January 12, 2024

**Re: Champion Xpress Car Wash  
5307 4<sup>th</sup> St NW  
Request for Certificate of Occupancy- 30 Day Temp  
Transportation Development Final Inspection  
Engineer's Stamp Date 5-31-22 (F14D036A)  
Certification dated 1-5-24**

Project Title: Champion Xpress Car Wash Hydrology File # F14D036A

CORNER SIDEWALK RAMP EXHIBIT

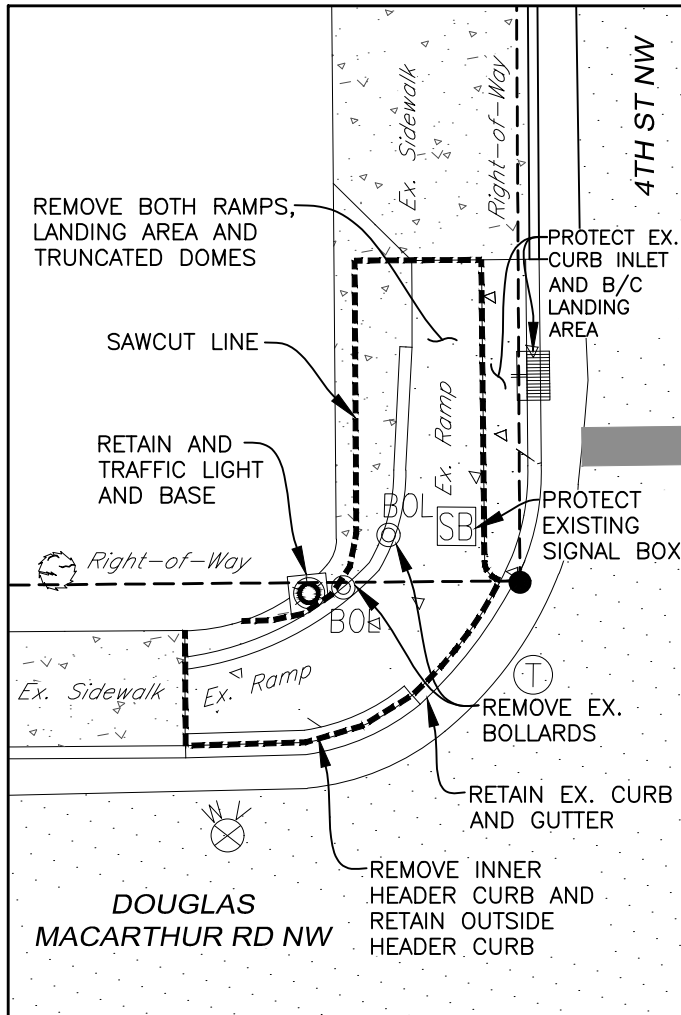
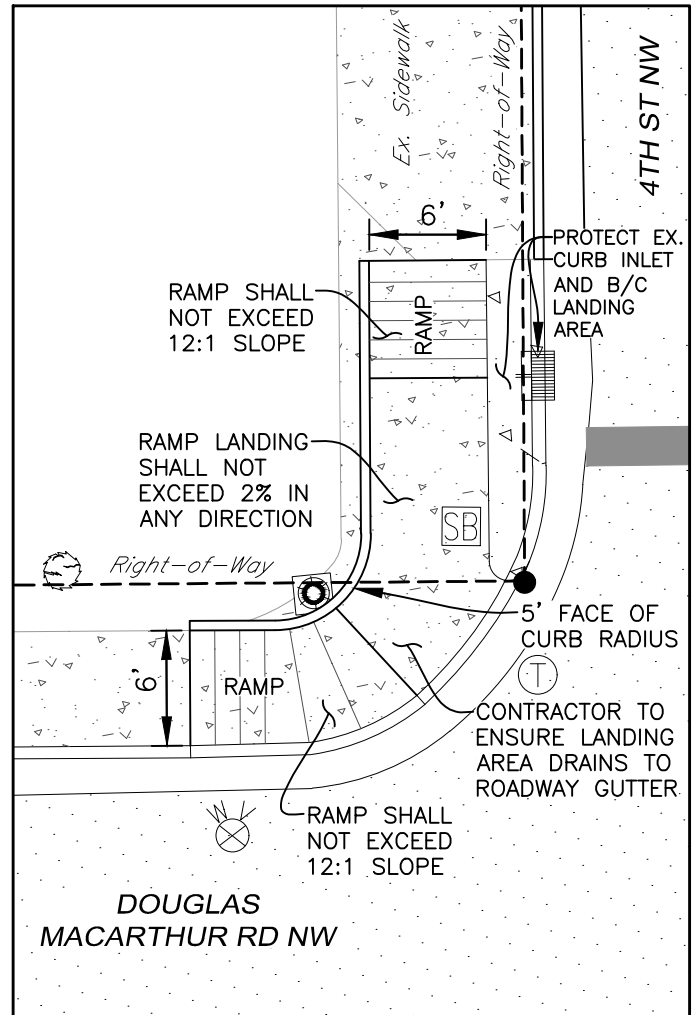
1. There were no pavement markings or signage in the employee parking area.
2. The 6' wide accessible path pavement marking was not installed.
3. Missing pavement markings and signage for the at the tunnel exit.
4. Missing transition sidewalk stone north of the ramp at 4<sup>th</sup> and Douglas Macarthur.
5. There were a couple of broken sidewalk stones on the Douglas Macarthur portion of the ramp at the 4<sup>th</sup> and Douglas Macarthur that are to be replaced and the ramp is not 6 feet (44", 60" and 57") wide as shown on the plan and some of the ramp needs to be replaced. I will follow up on this separately.
6. The landscape buffer on Douglas Macarthur was not finished. It needs fine grading and aggregate.
7. The bike rack was not installed.
8. Trim the tree on Douglas Macarthur so the branches don't hang over the sidewalk.
